Re: 102 Linden Rd Bognor - BR/34/20/PL - EXTENSION OF TIME

On reviewing the application I have noticed a couple of issues regarding the front boundary as follows:

01

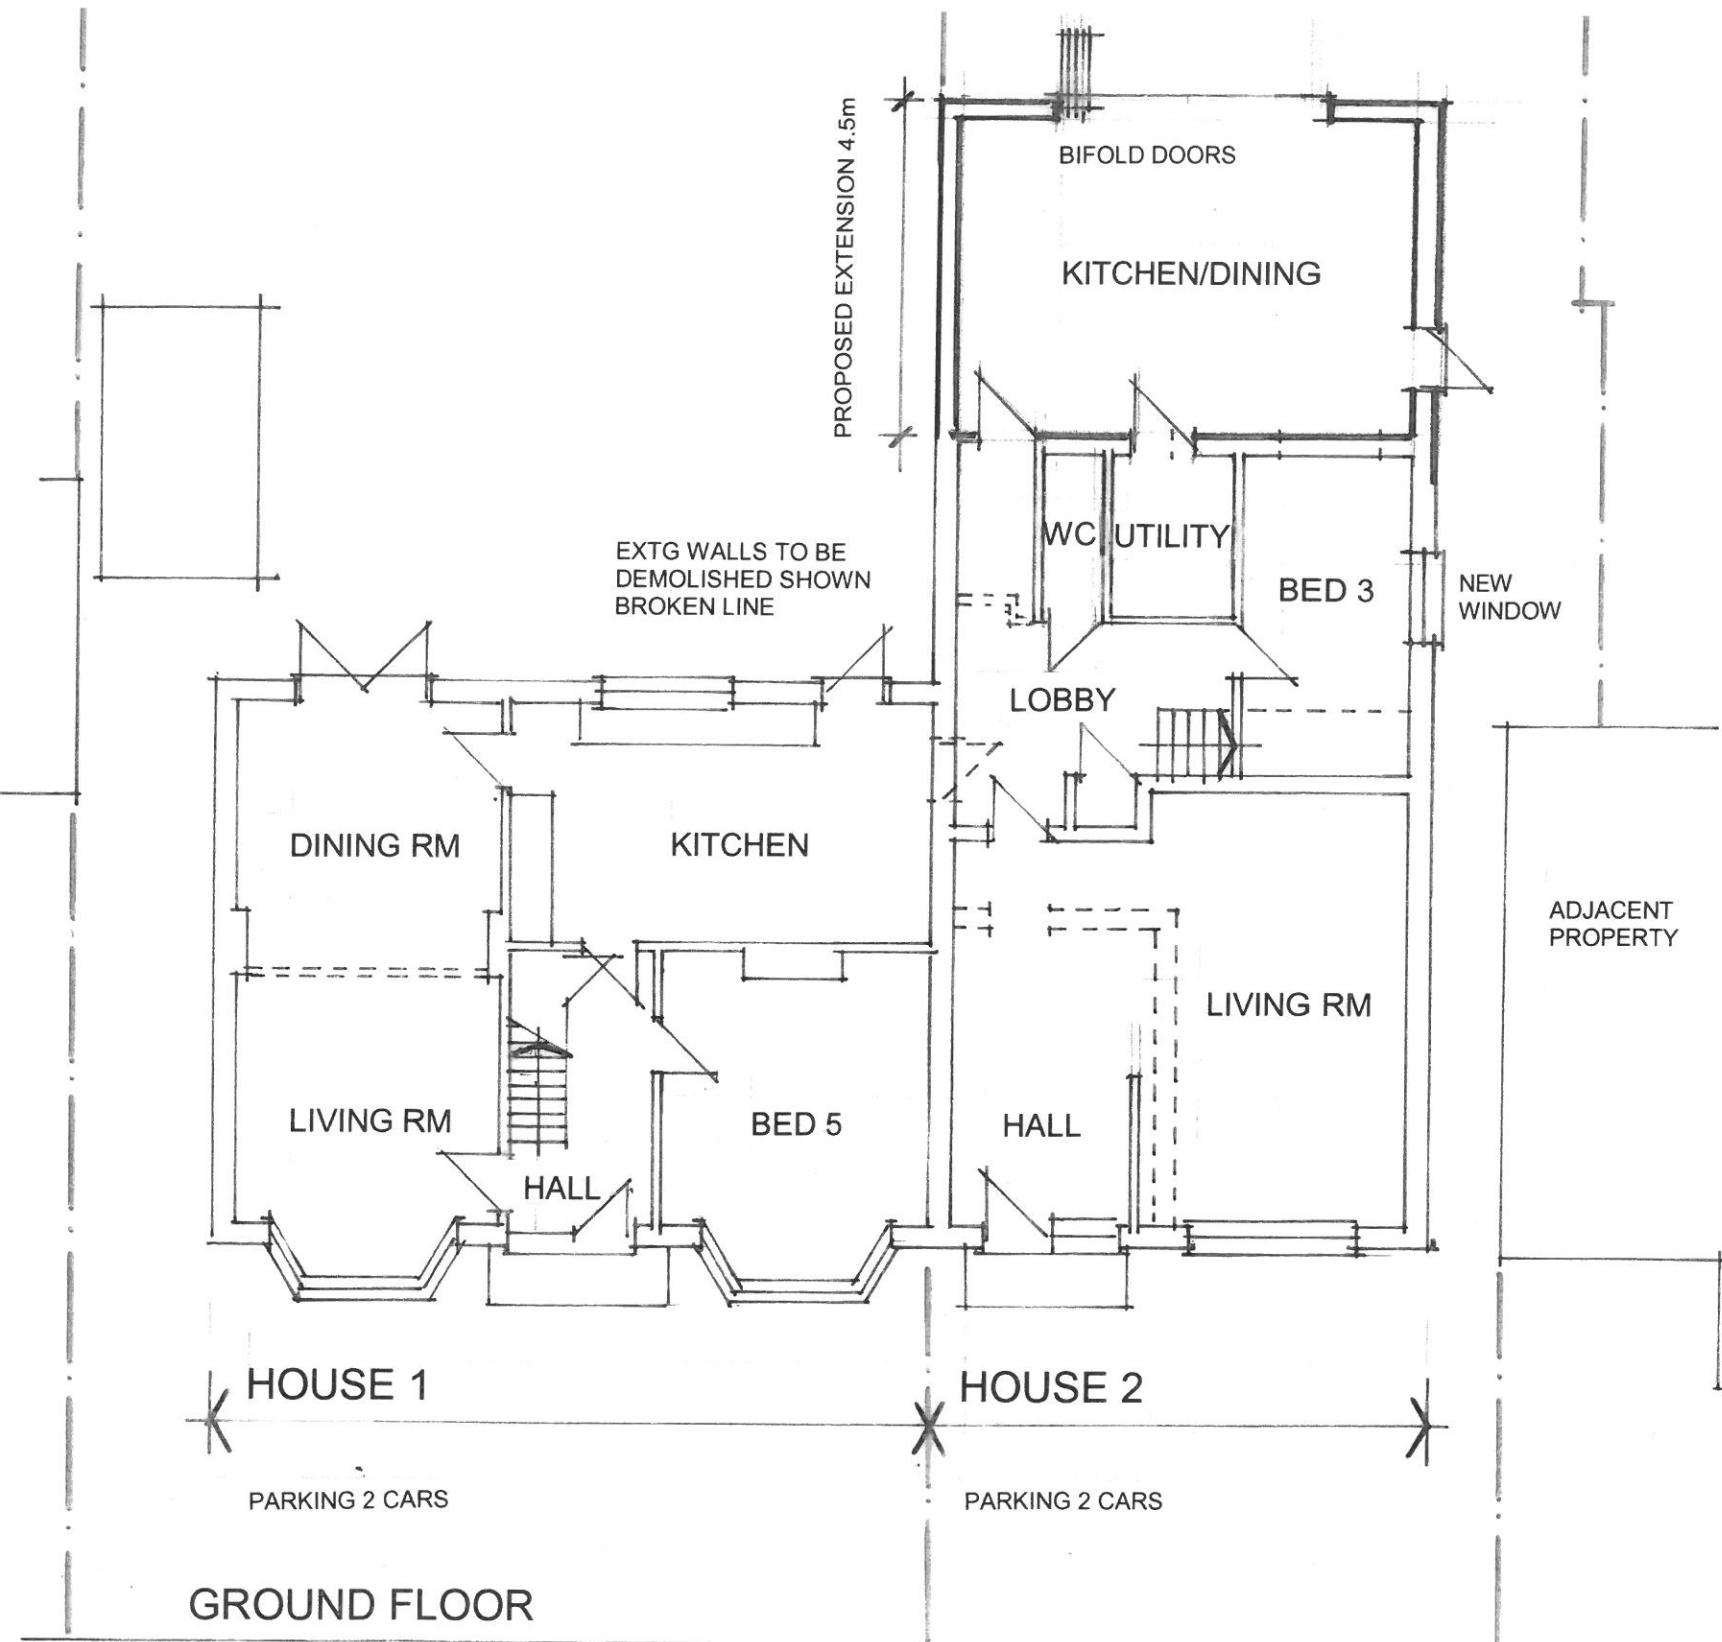
Also just to add to the requirements set out below, you need to mark where front garden area and where hardstanding would be, and also the side boundary between the 2 properties shown in elevation.

- Proposed Ground Floor Plan ref. 19/1135.01 – need to amend to include where section of front wall would be retained, entrance width for vehicle crossover (minimum 6m for 2 cars) with red arrow, and mark where side boundary would be between 2 properties
- Proposed Elevations ref. 19/1135. 02 – need to amend to include section of front wall to be retained/brick piers and mark the 2 vehicular entrances
